January 3, 2018

**Re: Picasso RV - 7800 Jacs Ln. NE
Grading & Drainage Plan Engineer's Stamp Dated 12/29/2017
(D16D002A6)**

**Re: Picasso RV - 7800 Jacs Ln. NE
Grading & Drainage Plan Engineer's Stamp Dated 11/21/2017
(D16D002A6)**

SECTION C-C
NTS

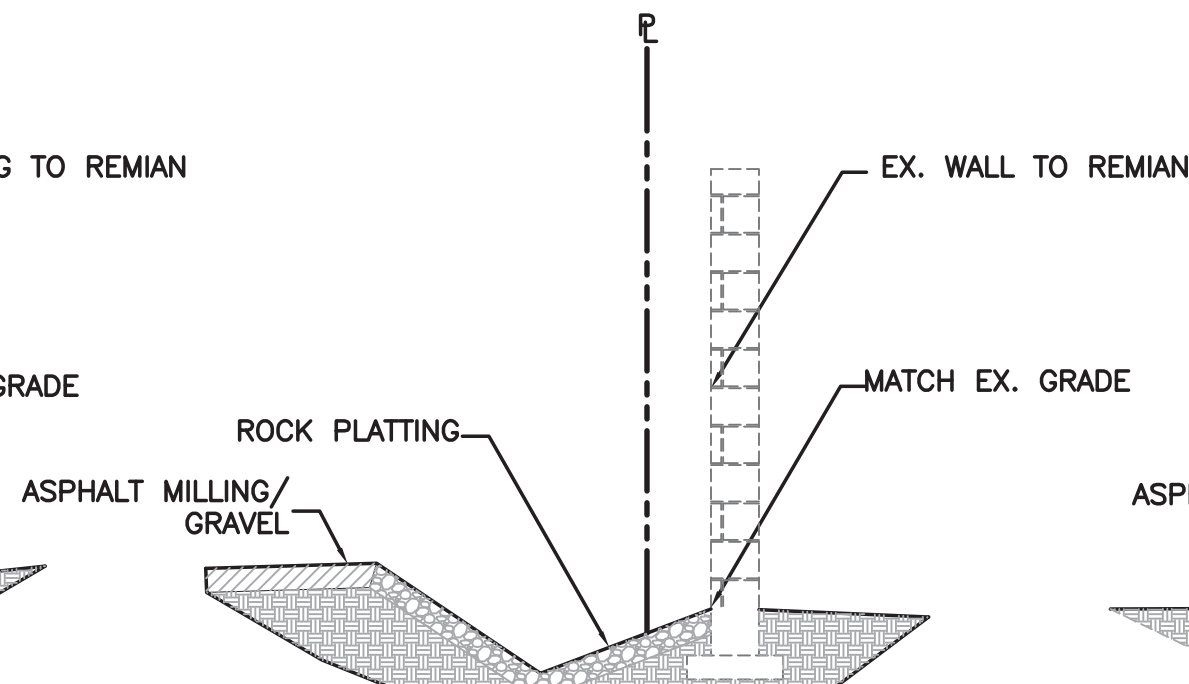
3. Similarly the hydraulic capacity calculations of the swale in section C-C should either be revised in the report to match the geometry of the section on the G&D Plan or the revised calculations can be shown on the G&D Plan next to the section. The detail and the calculations should agree. **We updated channel capacity**

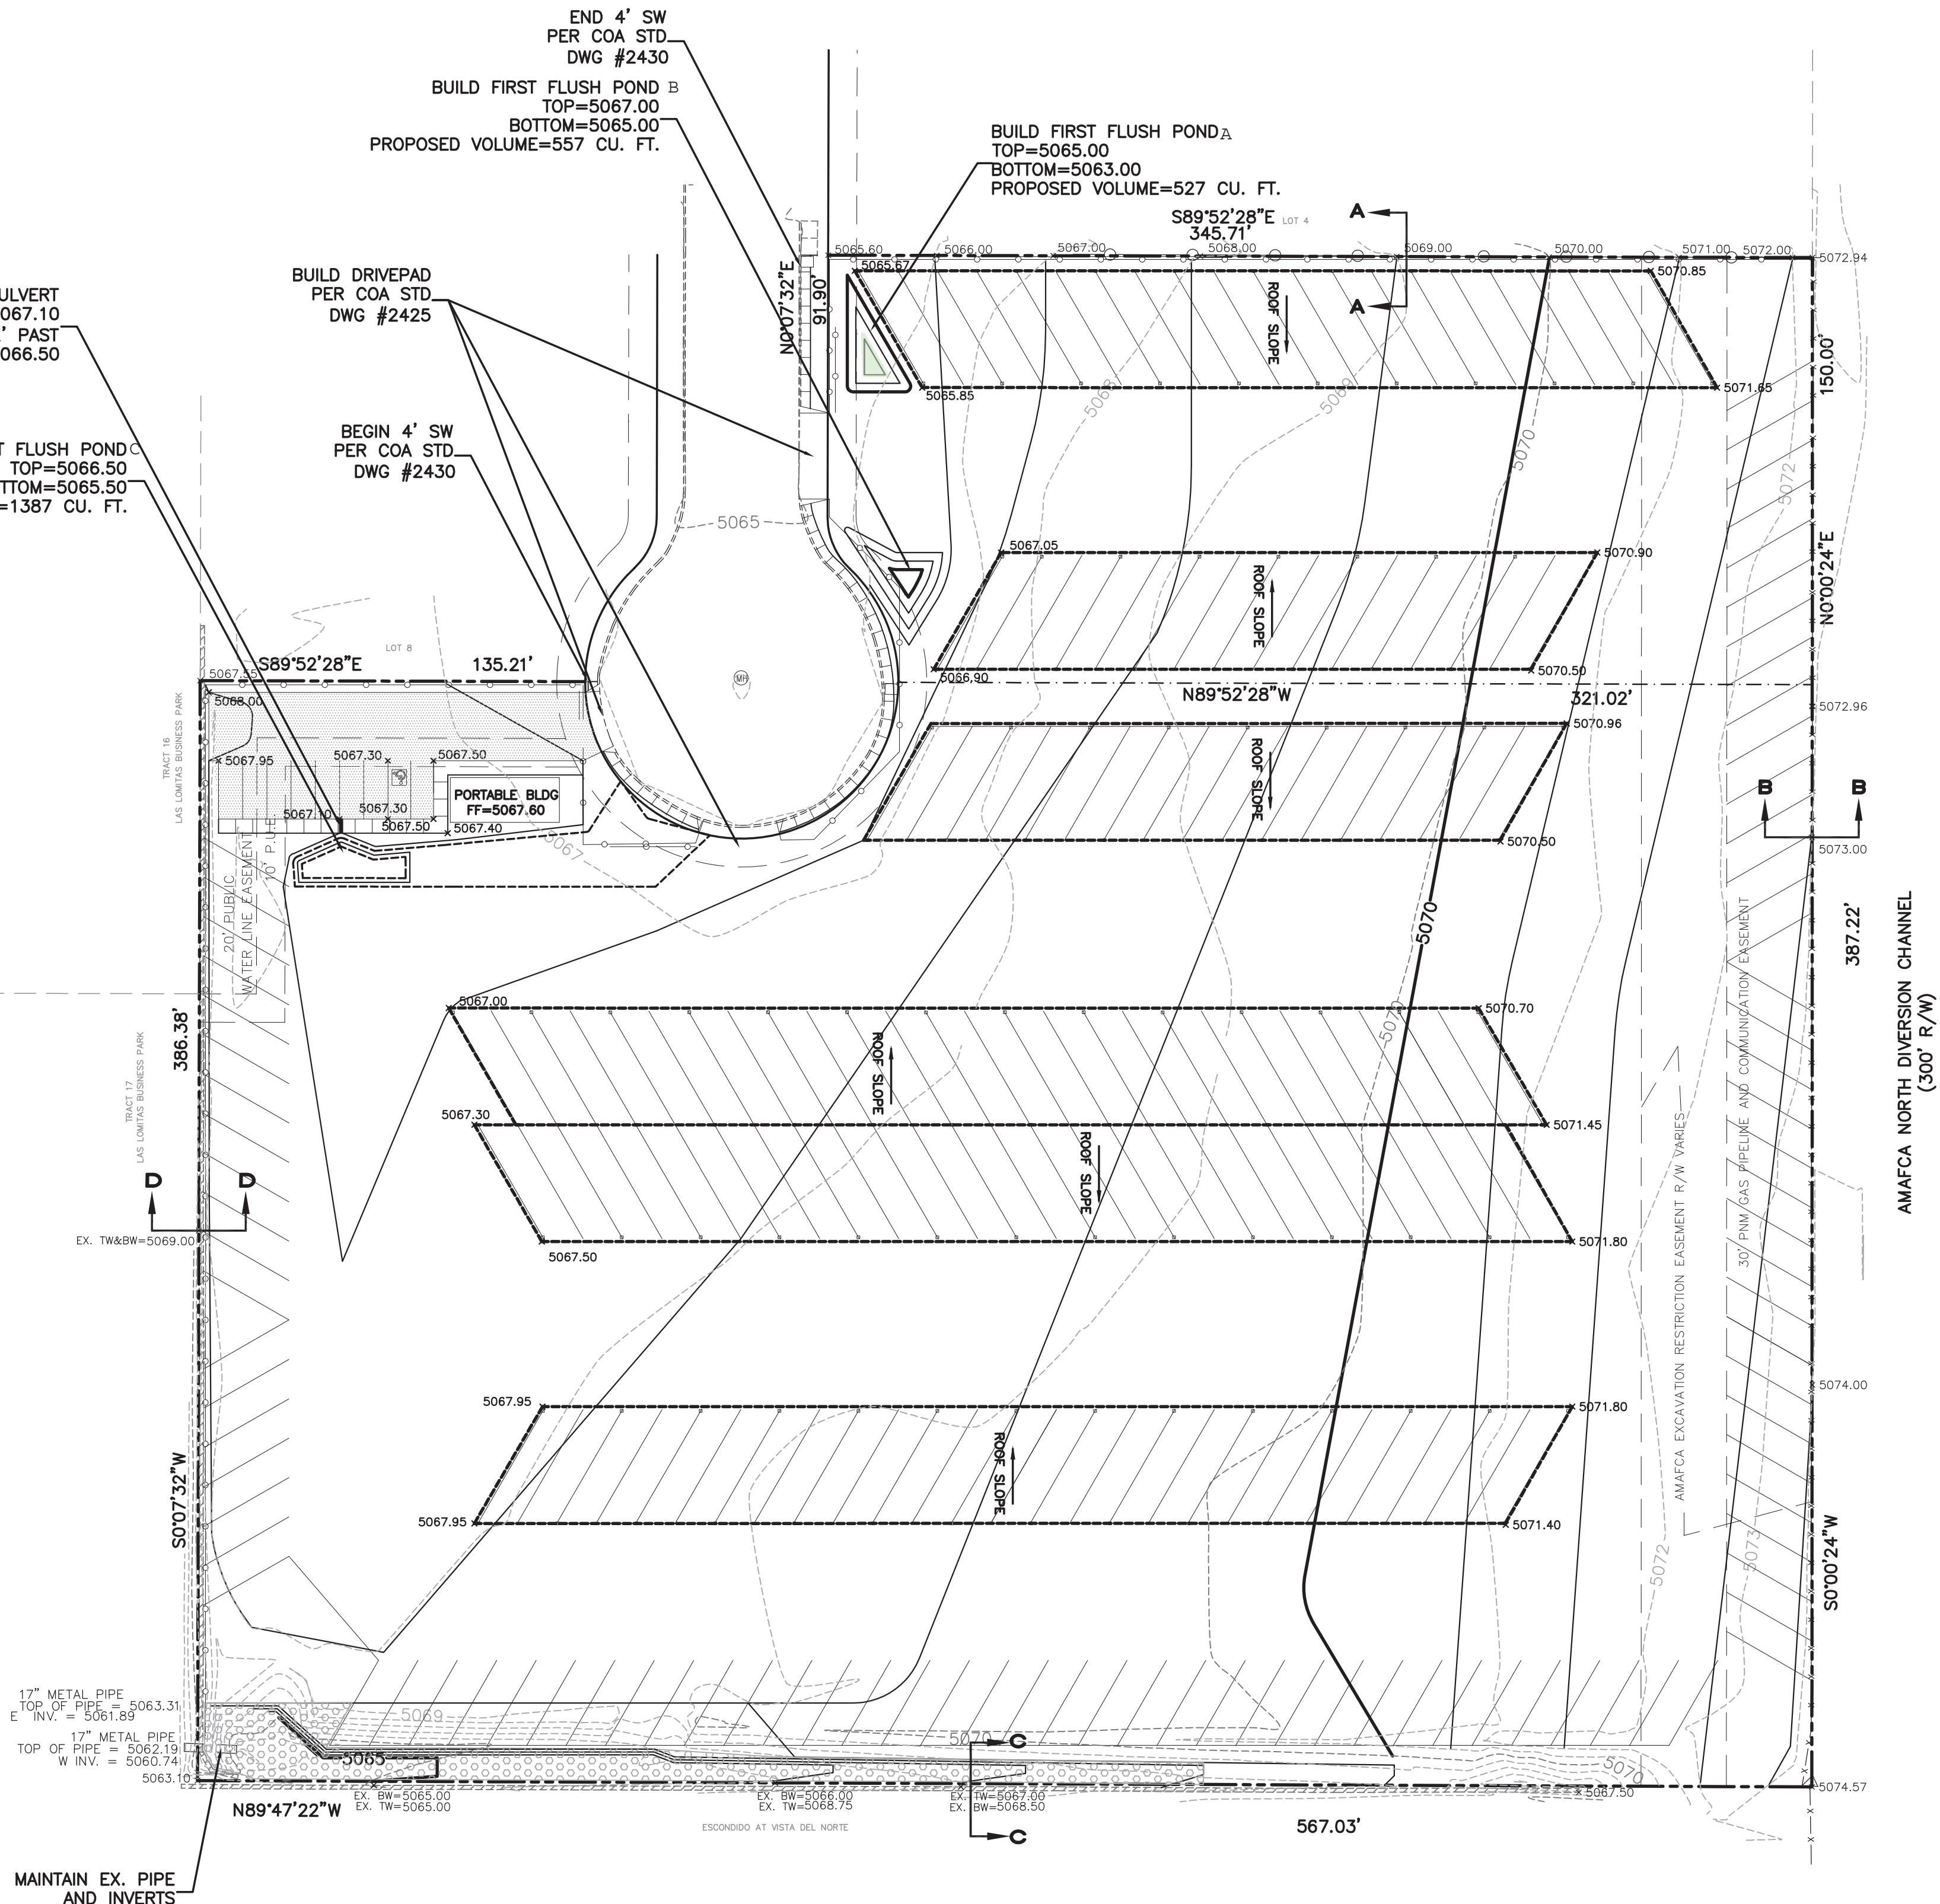
1. Flow arrows and spot elevations should be added showing the onsite swale next to Jacs Ln. that will divert onsite drainage into the ponds before it enters the public right of way. **We have adjusted contours and added arrows and spots**

4. Please add a big caution note in the vicinity of the existing 30' PNM Gas Pipeline and Communication easement on the east side of this property. **Added**
